Tracy Bellamy - Epping to Thornleigh Third Track Project - Application number SSI 5132

Epping to Thornleigh Third Track Proposal. Application number SSI 5132.

Figure 5.6 Cross-section and elevation - New Cheltenham Station concourse building
Note: Indicatively added to future design

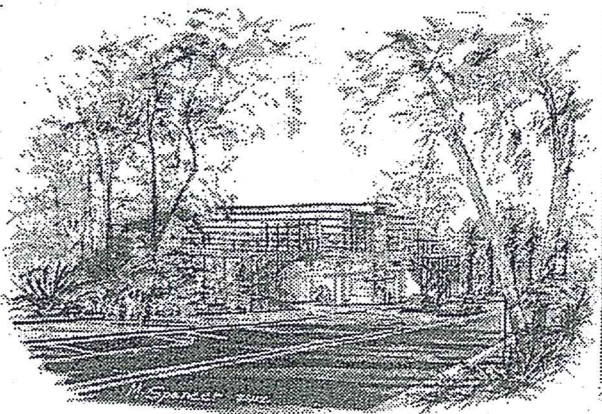
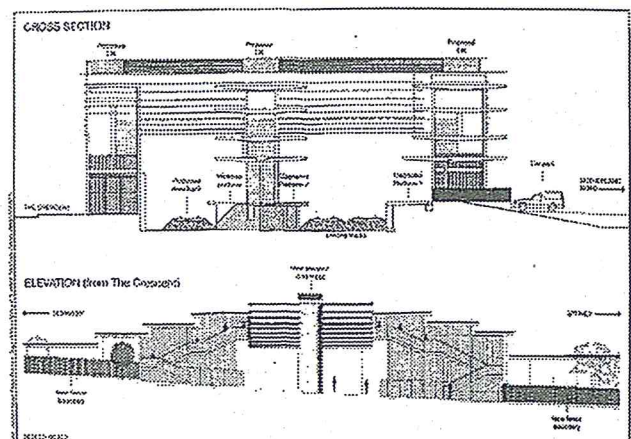
- The proposed redevelopment of Cheltenham Station shows no regard for the HCA. The visual impact of the proposed 13m high glass and steel concourse is totally unacceptable in this HCA.

Concept design drawing of proposed changes to Beecroft Station (Parsons Brinckerhoff 9/3/12). Former side platform shaded in pink.

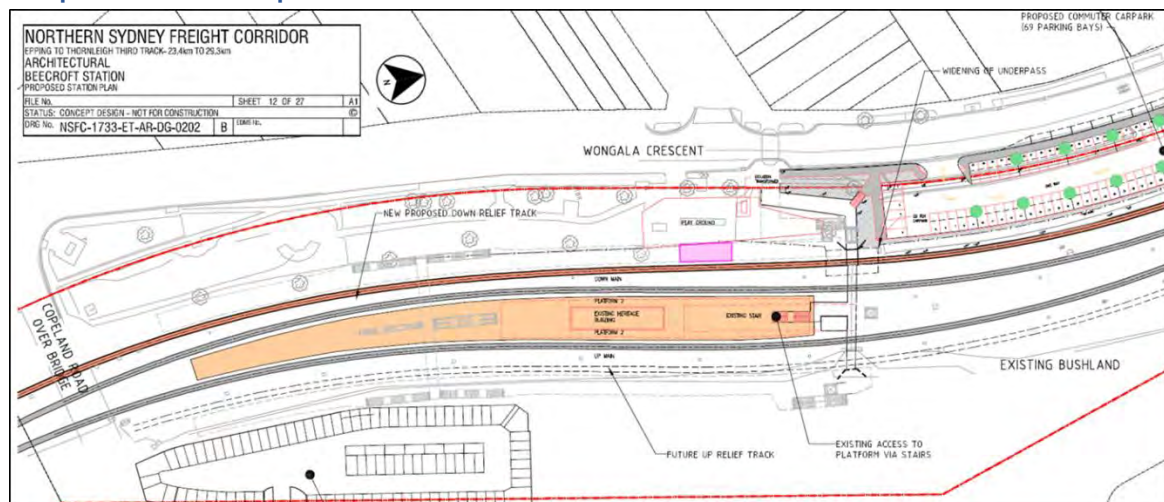
- There has been inadequate assessment of the project's impact on the fabric of the Beecroft Cheltenham Heritage Conservation Area (HCA).
- The plan given for Beecroft Railway station Precinct is vague. The relationship to the trees, playground and original 1895 platform located south of the present station is not shown. A fourth track is shown on the eastern side. The plan does not include urgently needed lifts to allow disabled access at Beecroft Station.

- Beecroft Station Gardens have a heritage listing with Hornsby Council but the impact on them has not been adequately addressed. No arborist's report is given for the trees which will be removed.
